RE: BL-18-00008 Clark Additional Information Needed

This letter is in regards to the application for a boundary line adjustment at parcel numbers 15893 (Map # 19-18-26000-0015) and 15897 (Map # 19-18-26000-0019). In order to continue processing the application, additional information is required as per a comment memo from Kittitas County Public Works (attached). A revised site plan with the following items must be submitted:

TO: Community Development Services
FROM: Taylor Gustafson, Environmental/Transportation Planner TG
DATE: June 18, 2018
SUBJECT: Clark BL-18-00008

CLARK PROPERTY

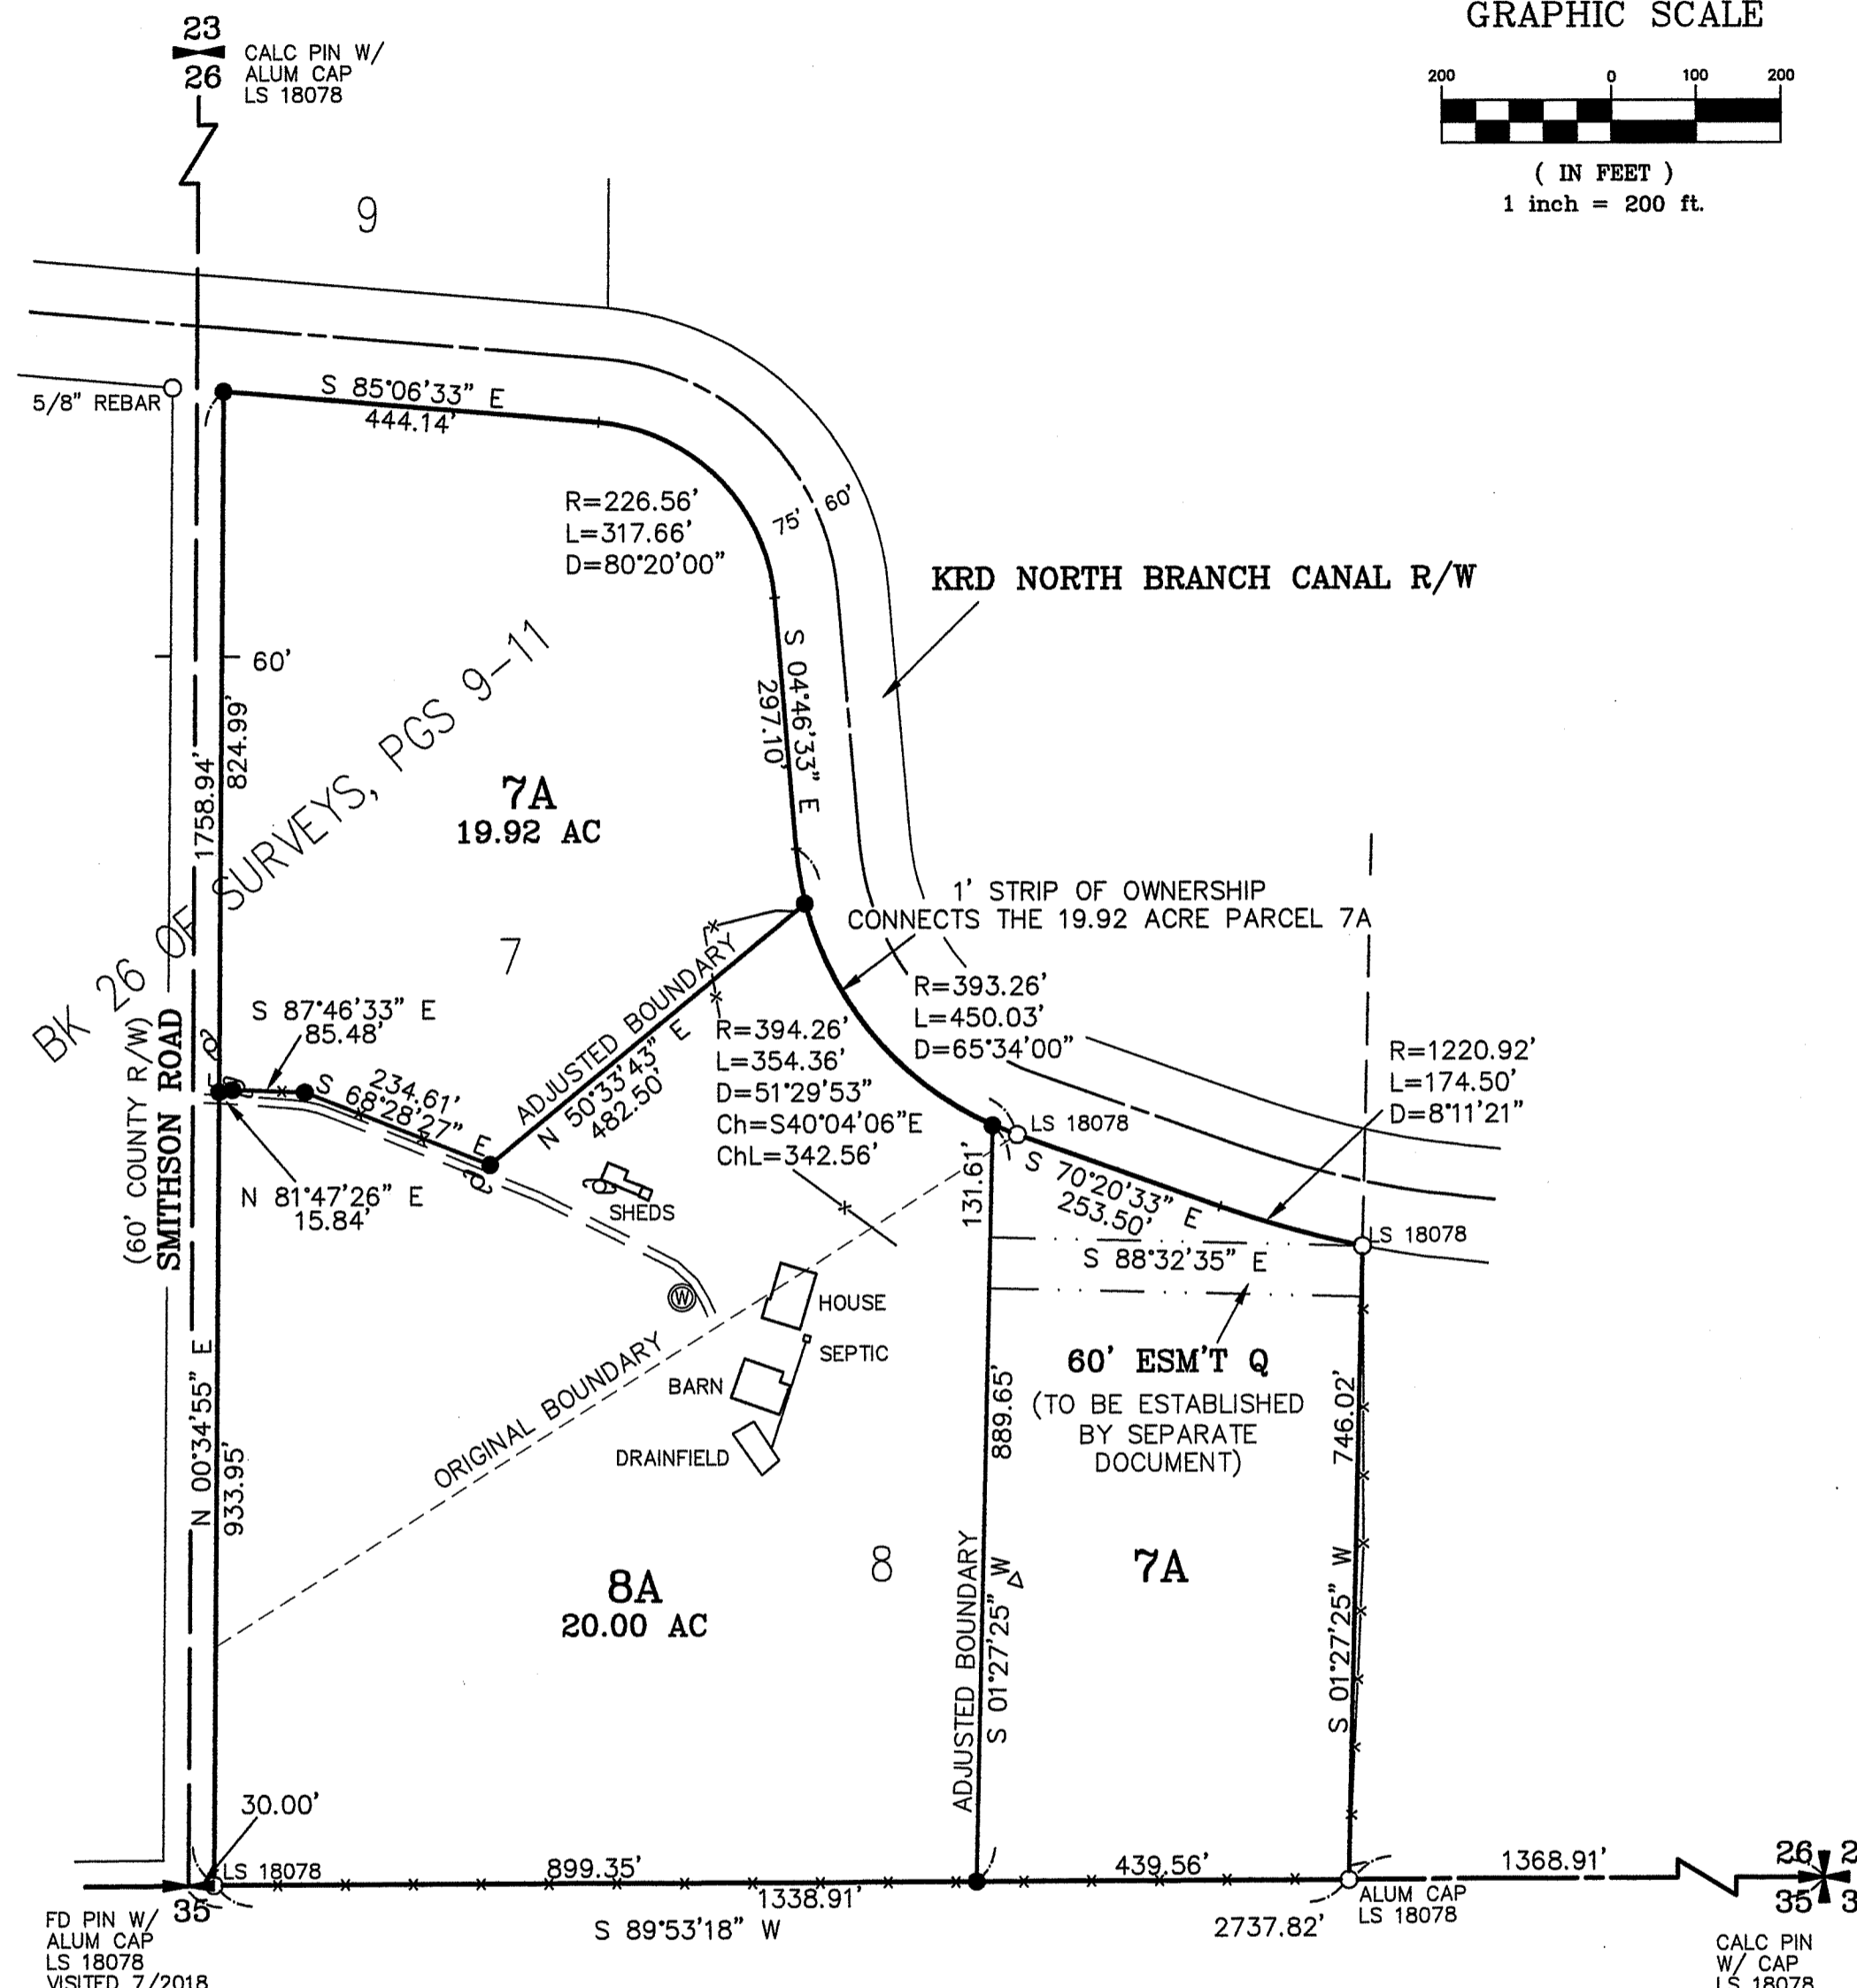
- 1) As proposed, the site plan shows insufficient access to the back half of lot #2. The revised site plan must show sufficient access.
- 2) The proposed map labels the County right of way as Church Road. The revised site plan must show the right of way as Smithson Road.

1. Provide sufficient access to the back half of lot 2. Proposed map shows only a 1' strip of land connecting the two sections.
2. Map shows County Right of Way as Church Road. Please relabel to Smithson Road.
